Application for a Non-Material Amendment Following a Grant of Planning Permission Town and Country Planning Act 1990 (as amended)

Demolition of existing garage and workshop and erection of single and part two storey side extension

2023/62/93404/W

Reduce the height of the two storey side extension to single storey side extension

Client: Mr & Mrs Hide	
Project: 8 Tor View Brockholes HD9 7BQ	
Drawing: Proposed Layouts	
Date: Nov 2023	Scale: 1:100 @ A3
Drawing No: 2327/112	Rev: A

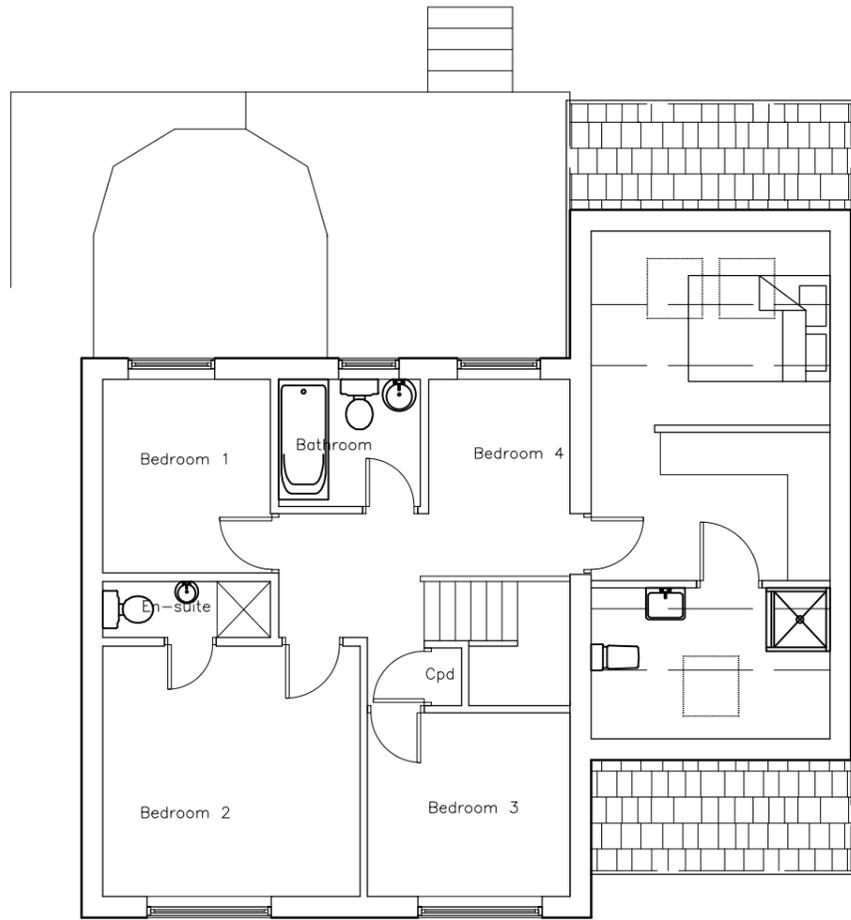
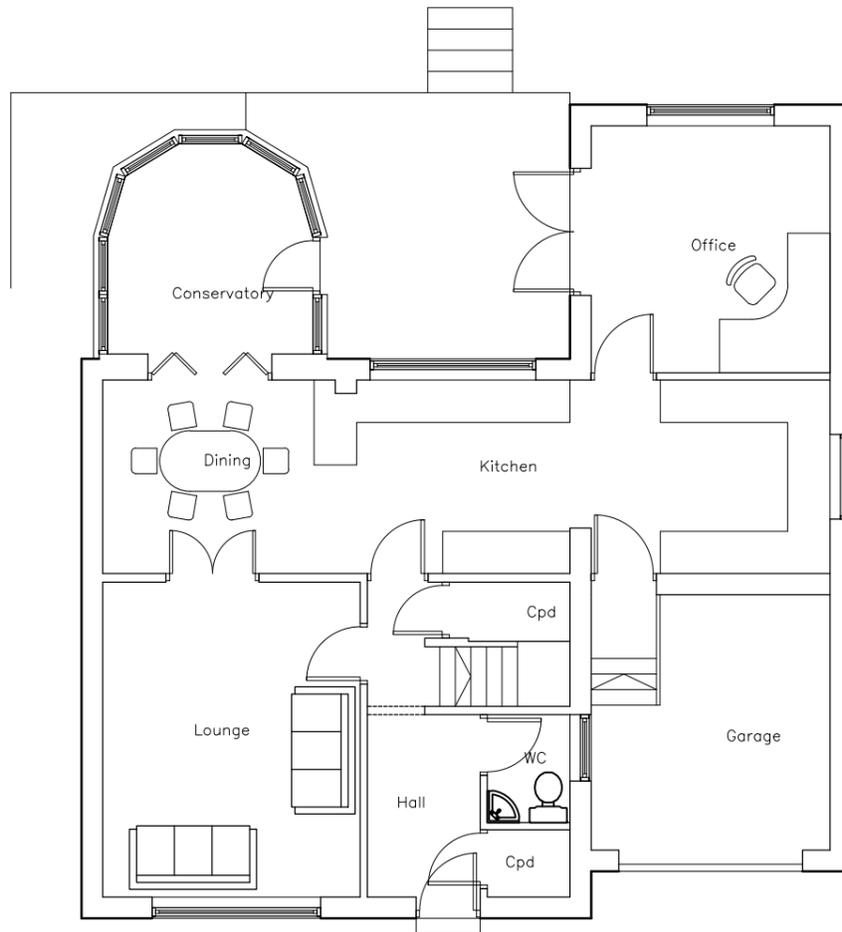
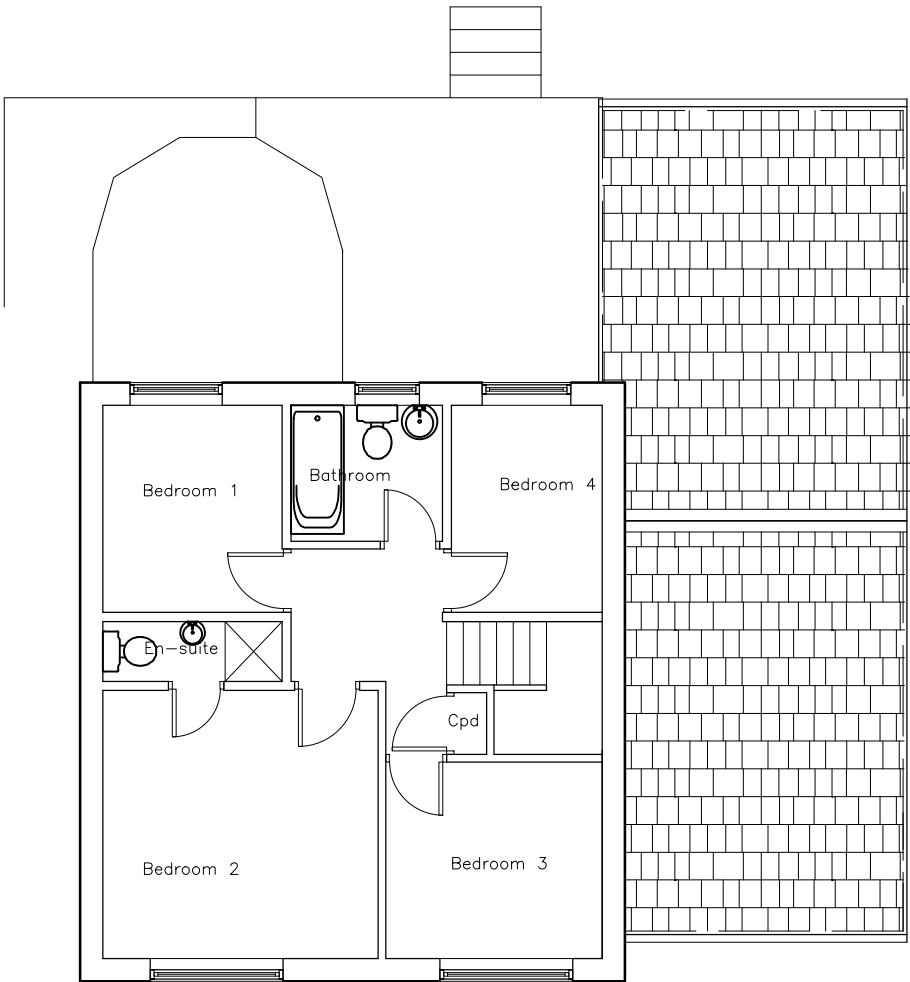
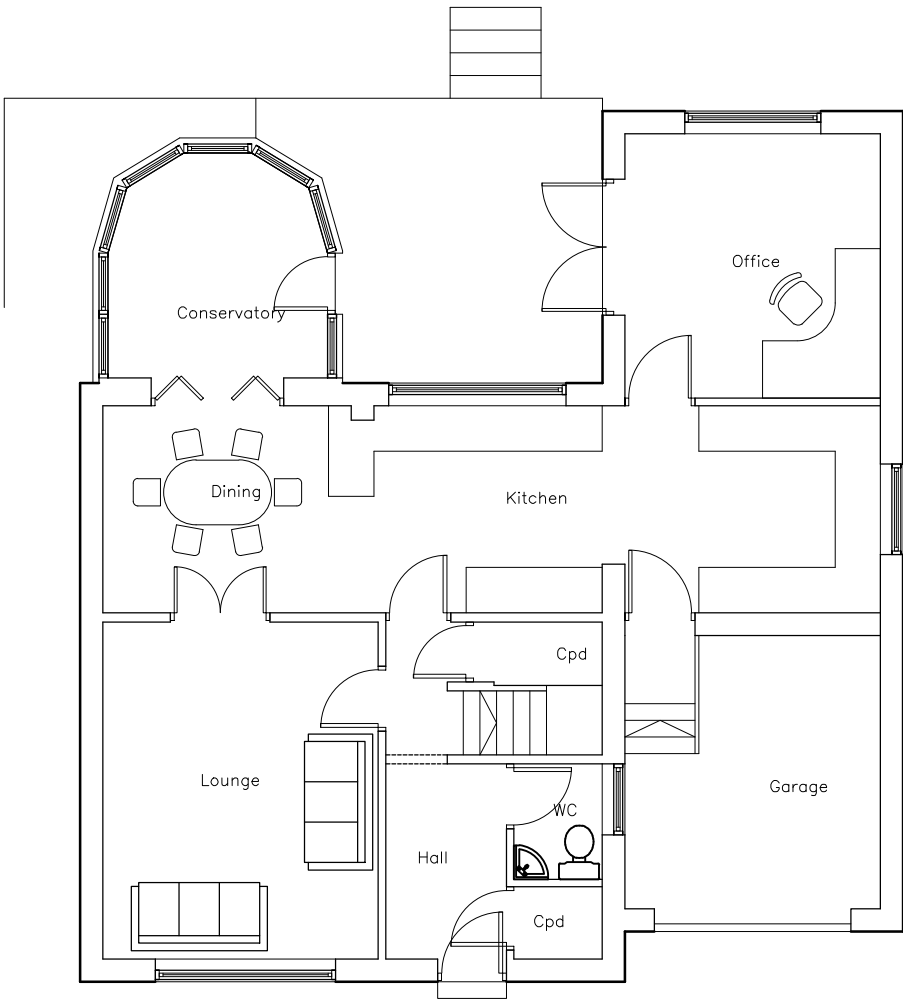
110, 111, 112

110A, 111A, 112A
